# CITY OF ALBUQUERQUE

Site: Beehive Montano

**Re: Drainage Ordinance (14-5-2-1) Violations for Erosion and Sediment Control**

SWPP PLAN
SCALE: 1"=20'

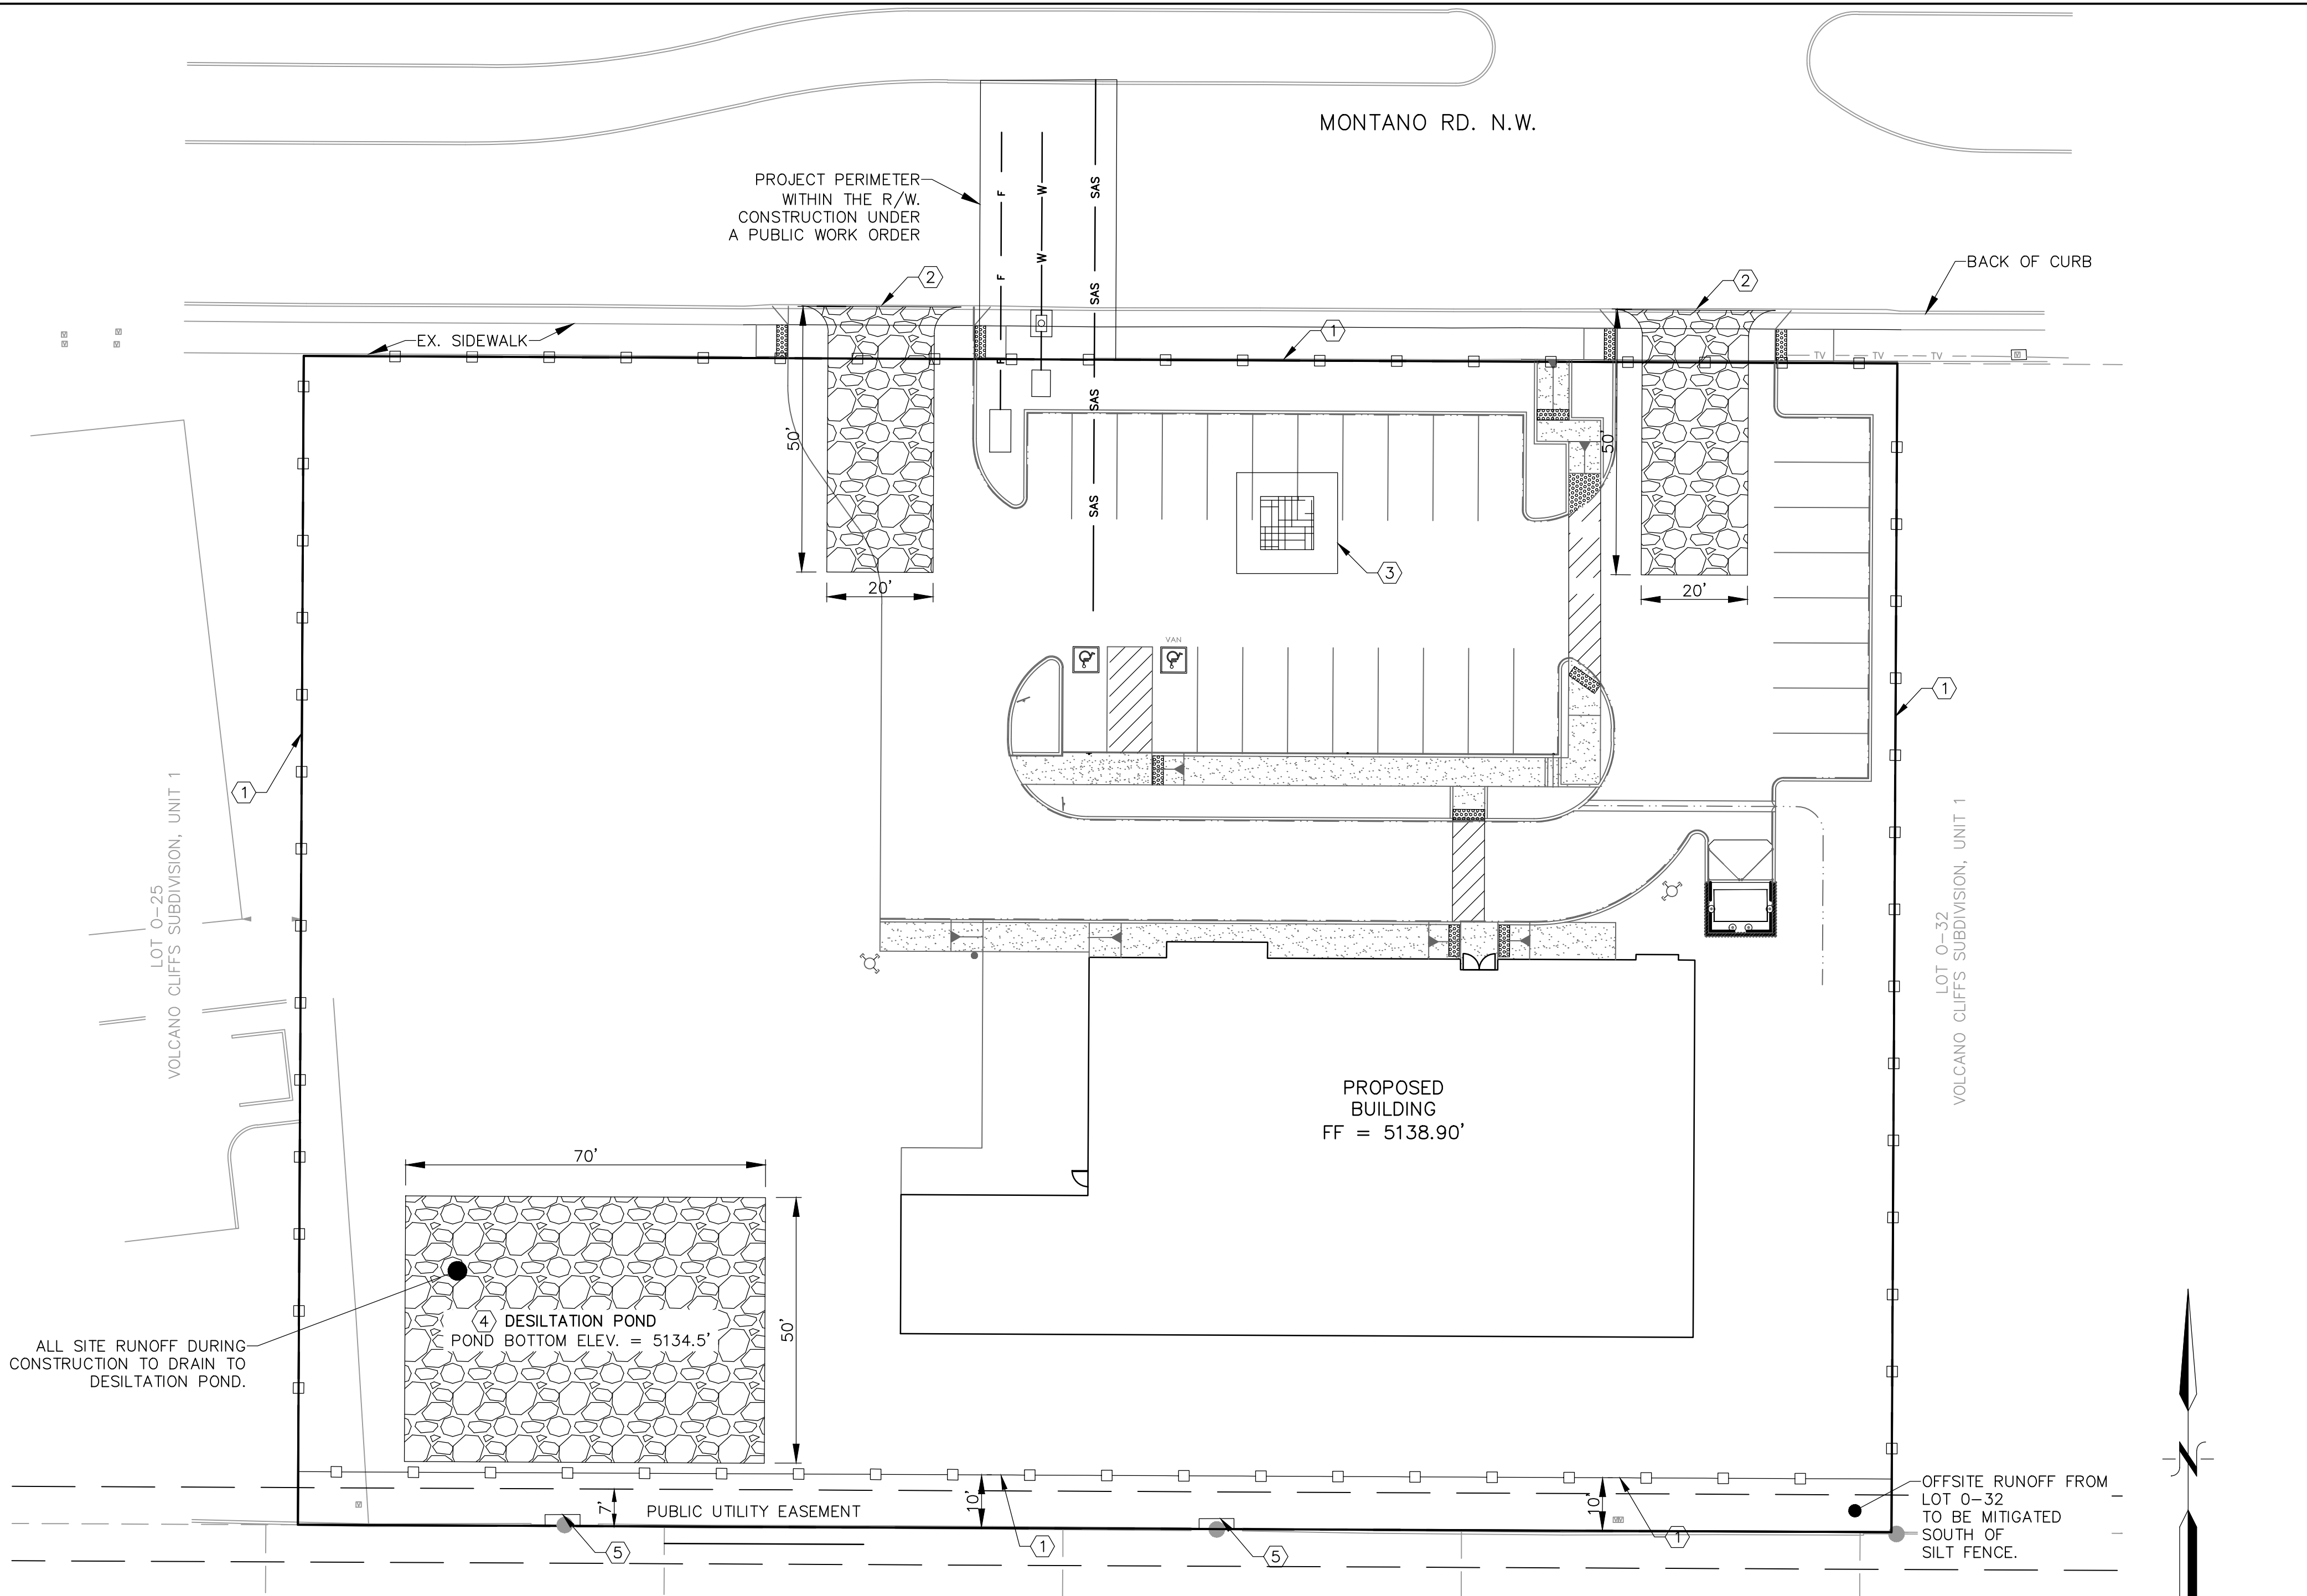
1. A dirt ramp was placed in the street to access the site.
2. Sediment in Montano Rd.
3. No stabilized Construction Entrance (track-out pad).
4. Grade too high between sidewalk and back of curb.
5. Missing sediment BMPs (straw logs on plan) in front of gates along southern edge.

No sediment BMP at gate.

1. Remove dirt ramp from Montano Rd. Usually lumber in the gutter or cold mix can be used to help gain access to a site over the curb. In this case, since Montano is a fairly high speed and busy road, the recommendation is to cut the curb. Curb cut permits can be obtained at Plaza del Sol 8<sup>th</sup> floor, Construction Services.
2. Remove the sediment from Montano Rd and gutter pan; from the site to approximately 100 feet east.
3. Install a Stabilized Construction Entrance (track-out pad) per approved plan.
4. Lower the grade between the sidewalk and back of curb in the vicinity of the dirt ramp to approximately 2 inches below the top of curb.
5. Install sediment BMPs in front of gates along southern edge. The approved Erosion and Sediment Control plan specifies straw logs, but mulch socks or straw wattles could also be used.
